El Paso County School District 49 Transportation Center, PPR-22-36

Please accept the following comments from El Paso County Public Health for the project referenced above:

SHEET TITLE  
INITIAL  
EROSION  
CONTROL PLAN  
A

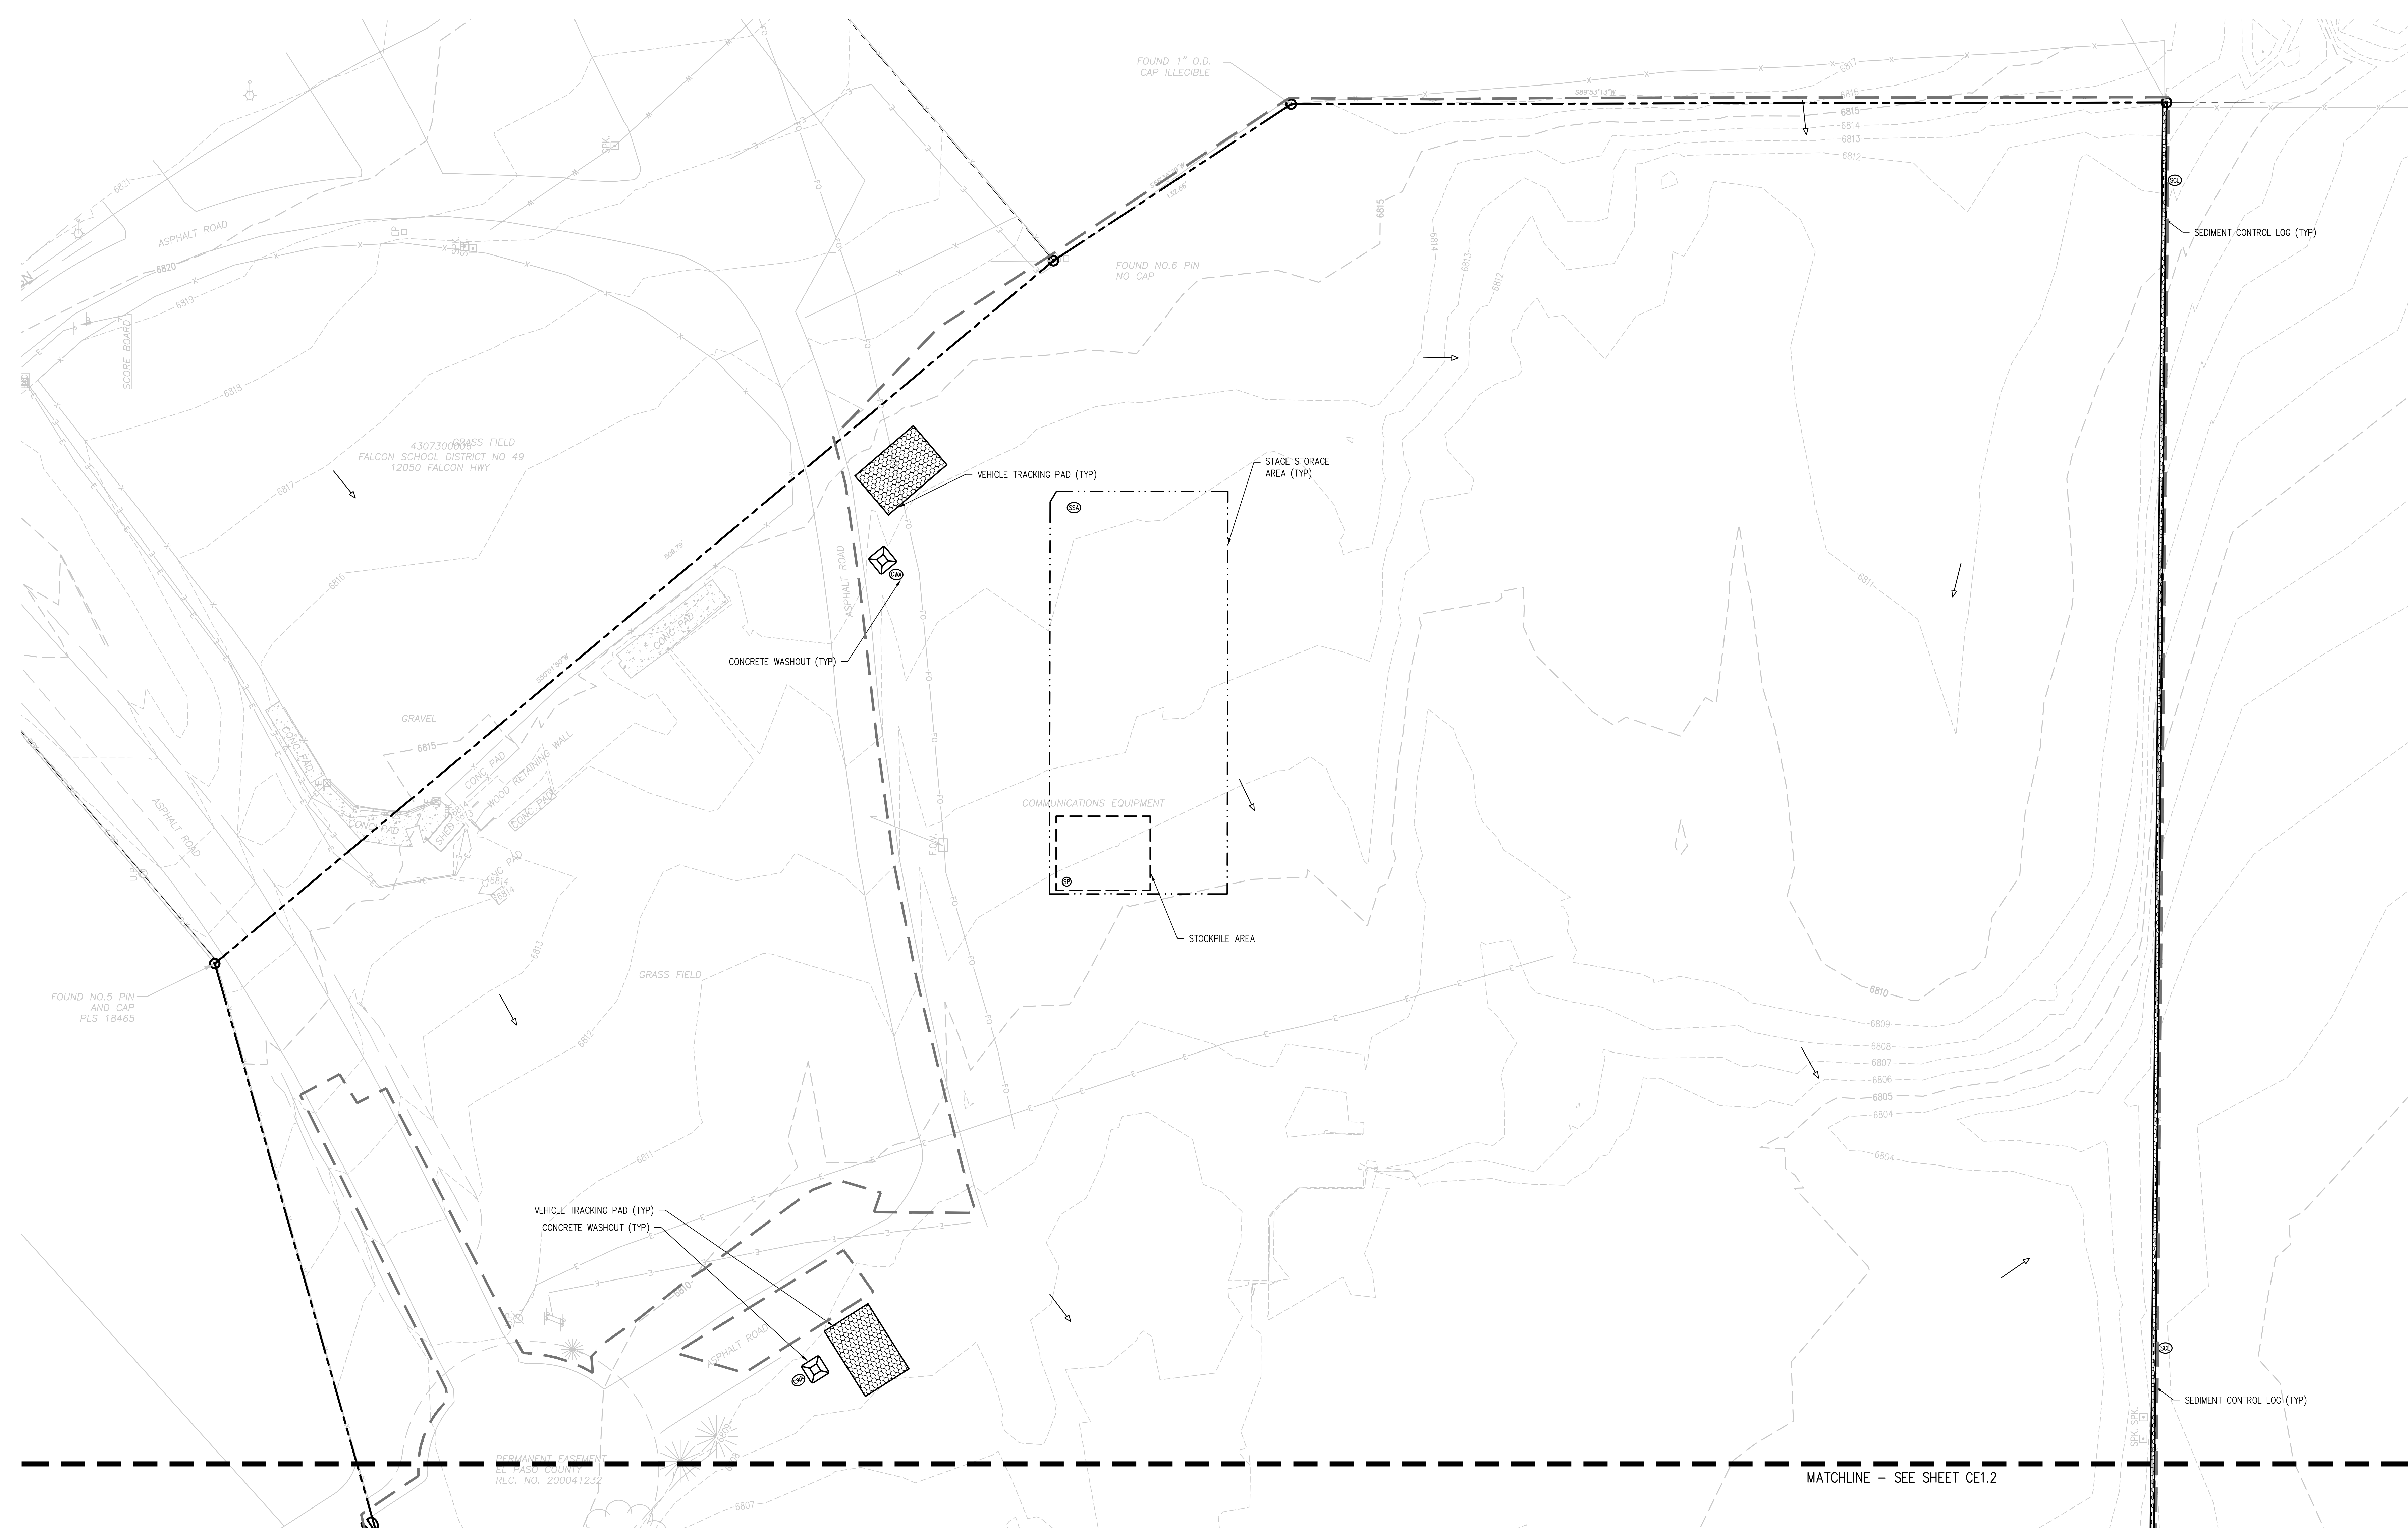
- **The water quality basins must have mosquito control responsibilities included as a part of the construction design and maintenance plan to help control mosquito breeding habitat and minimize the potential for West Nile Virus.**
